**KIRKLEES METROPOLITAN COUNCIL
INVESTMENT & REGENERATION SERVICE**

DELEGATED DECISION TO DETERMINE PLANNING APPLICATIONS

Reference No:	2023/62/92928/E
Site Address:	Land at, Taylor Hall Lane, Mirfield, WF14
Description:	Erection of 4 dwellings
Recommending Officer:	Nicole Helliwell

Officer Report

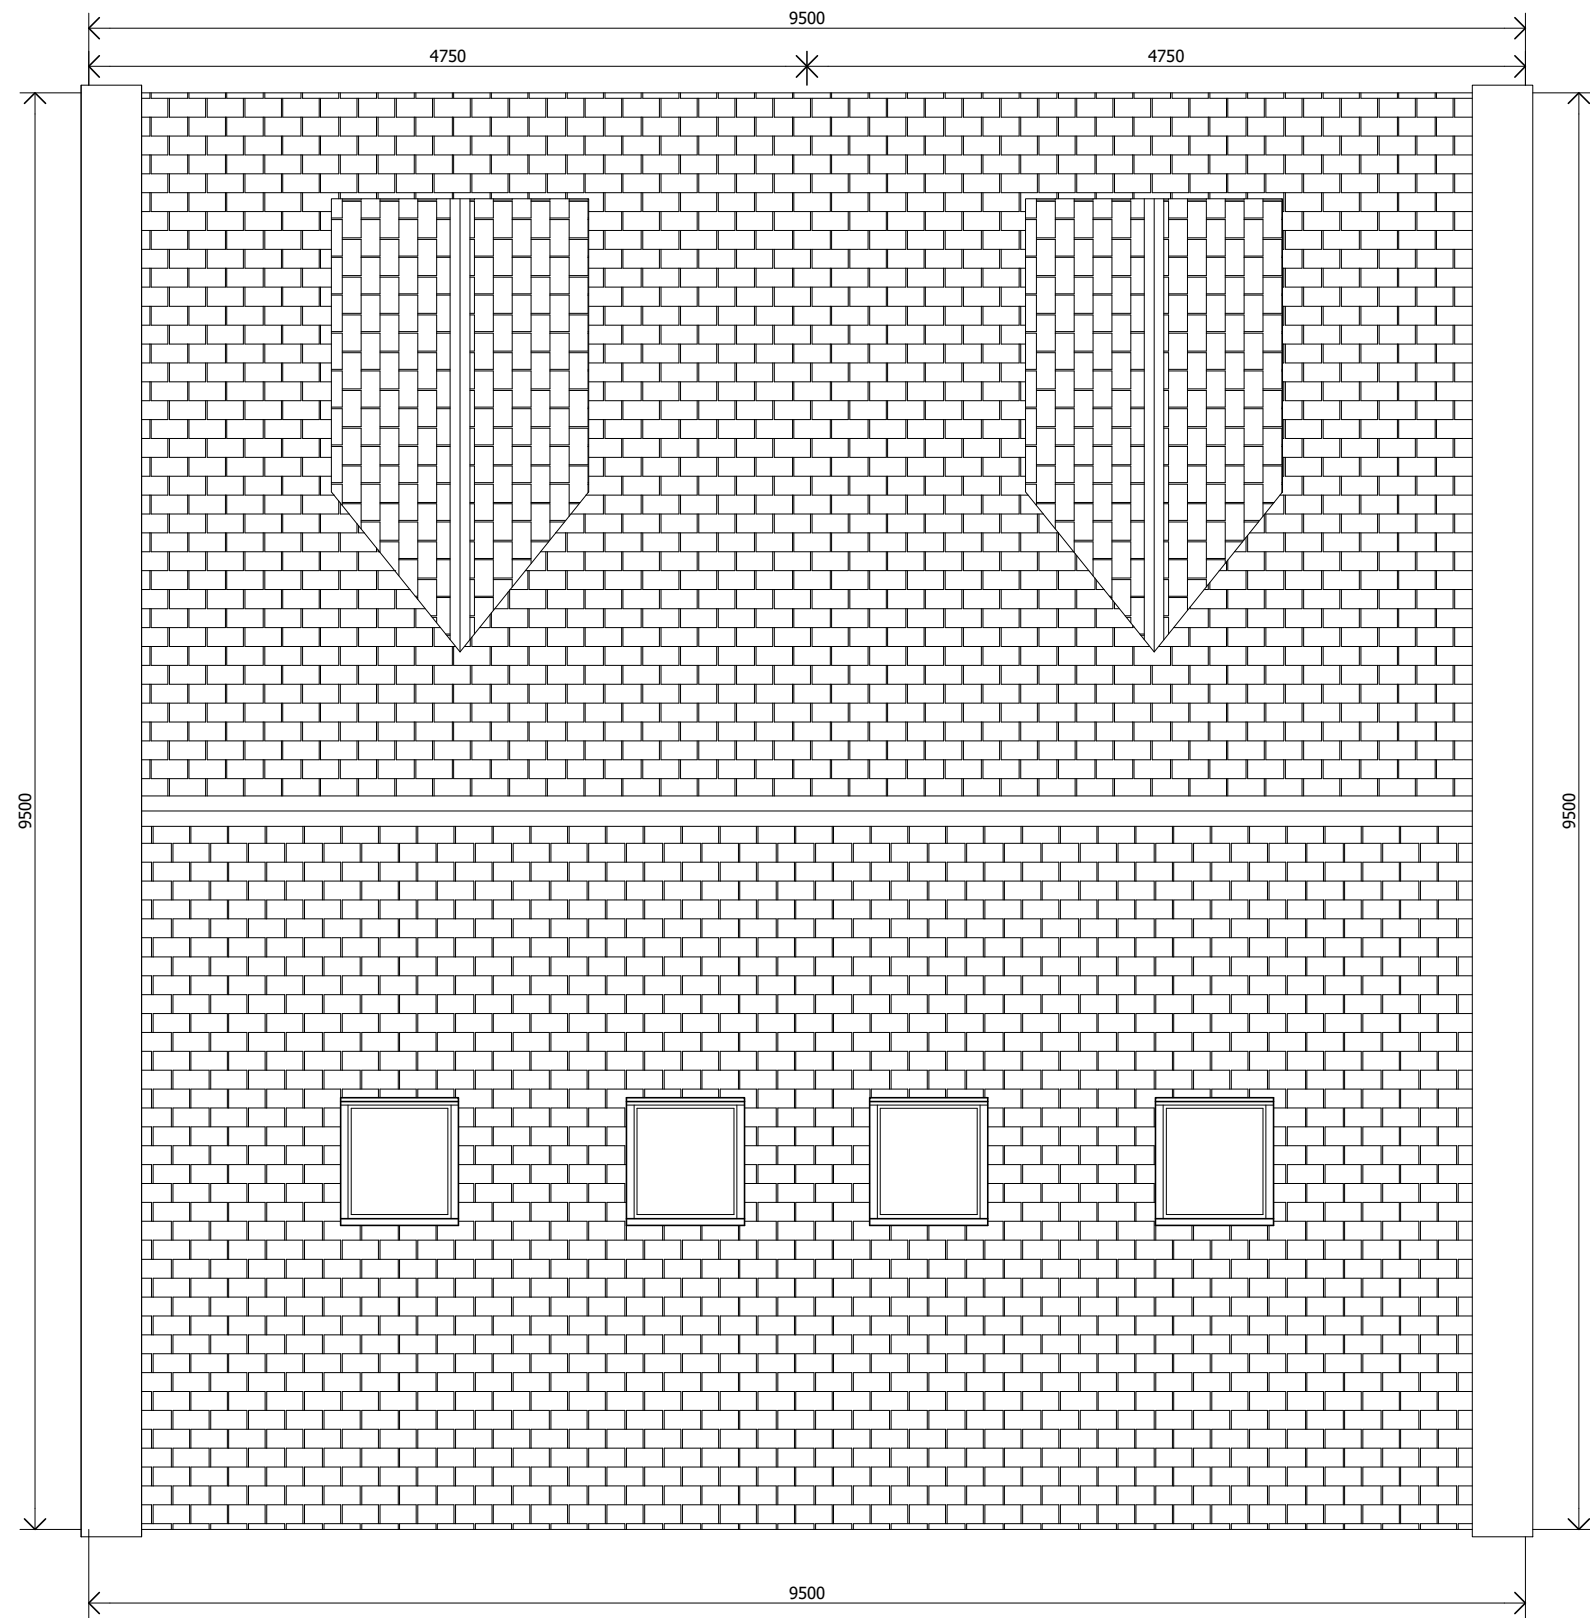
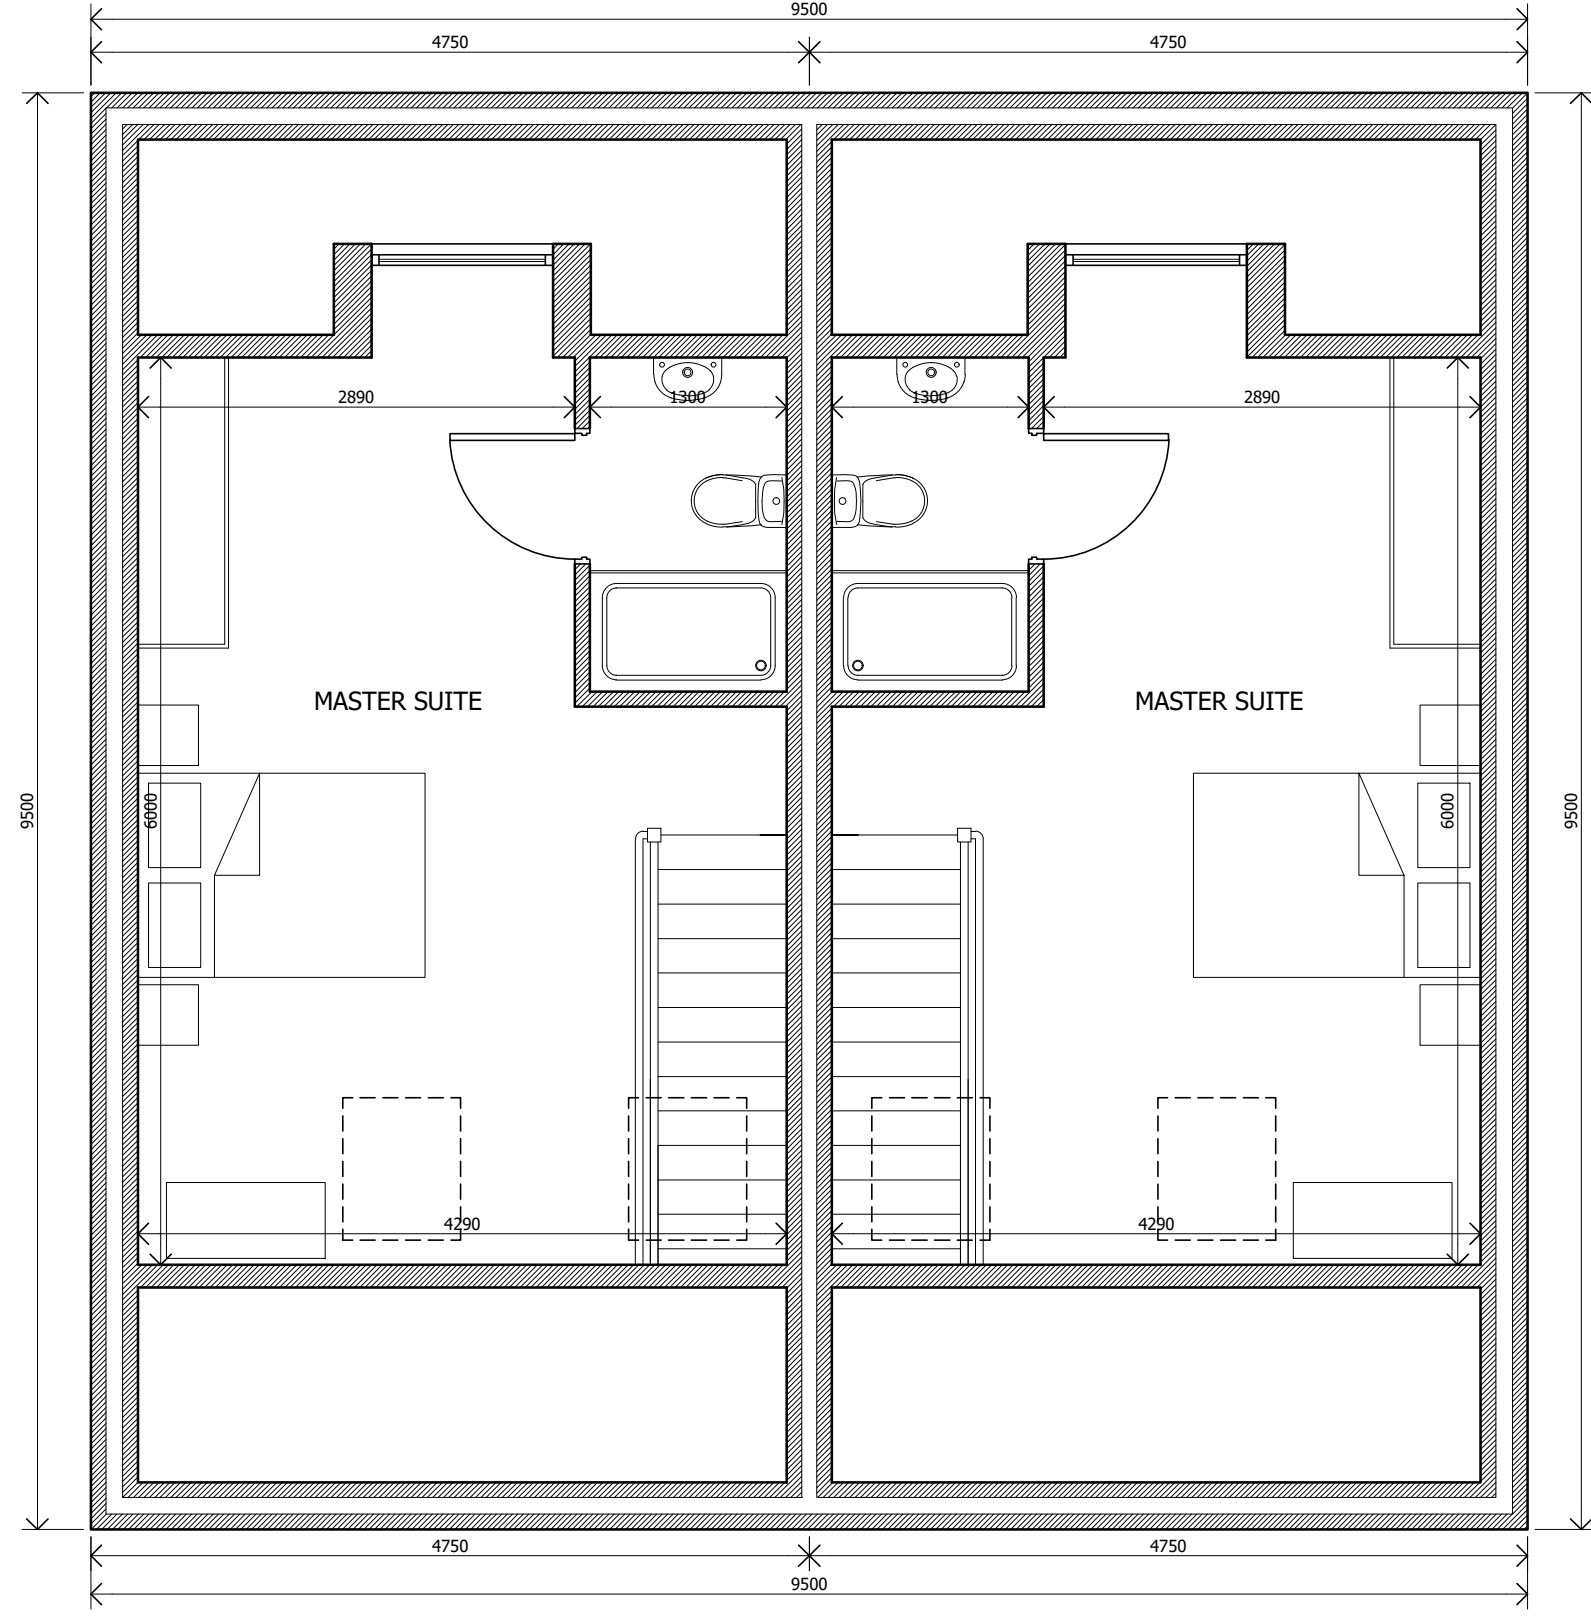
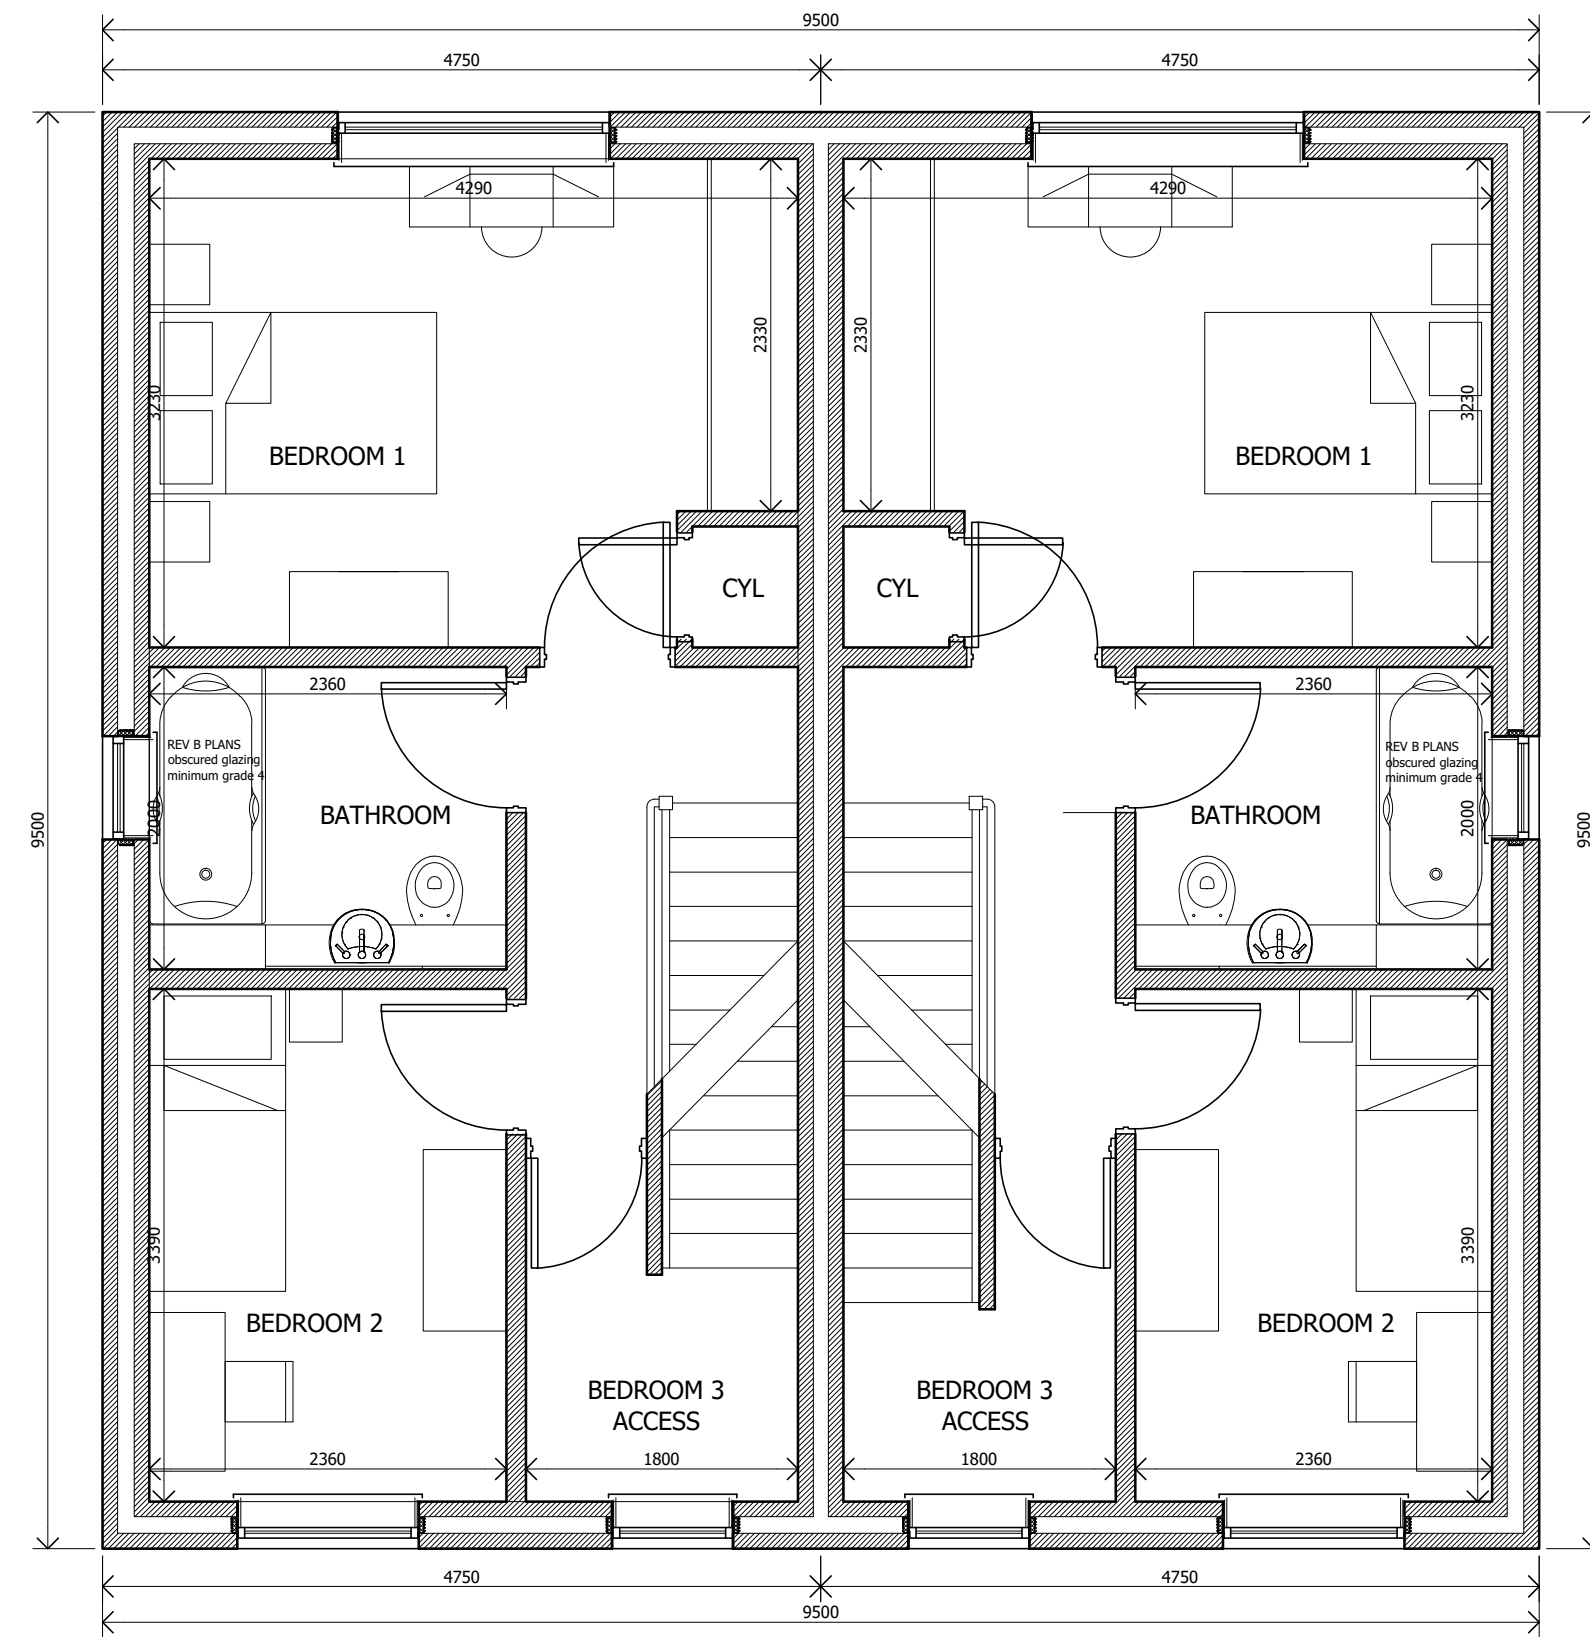
The proposed floor plans show that the properties would have three bedrooms and therefore are required to have a minimum internal floor space of 99m². The dwellings are shown to have an internal floor space of 102.7m², which would adequately meet basic lifestyle needs and provide a high standard of amenity for future occupiers. It is also noted that each of the habitable rooms would benefit from a sufficient amount of natural light. Furthermore, private outdoor amenity spaces are proposed to the rear of the properties and areas of off road parking are proposed to the front of the site. For these reasons, it is considered that the proposal would provide an acceptable standard of living for future occupants and would accord with LP24(b) of the Kirklees Local Plan, Principles 6 and 16 of the Council's Housebuilders Design Guide SPD, and Paragraph 135(f) of the National Planning Policy Framework.

Amendments were sought during the course of the application. Concerns were raised regarding the internal floor space of the dwellings as they failed to accord with the nationally described space standards. Revised drawings were received which were considered acceptable in terms of residential amenity.
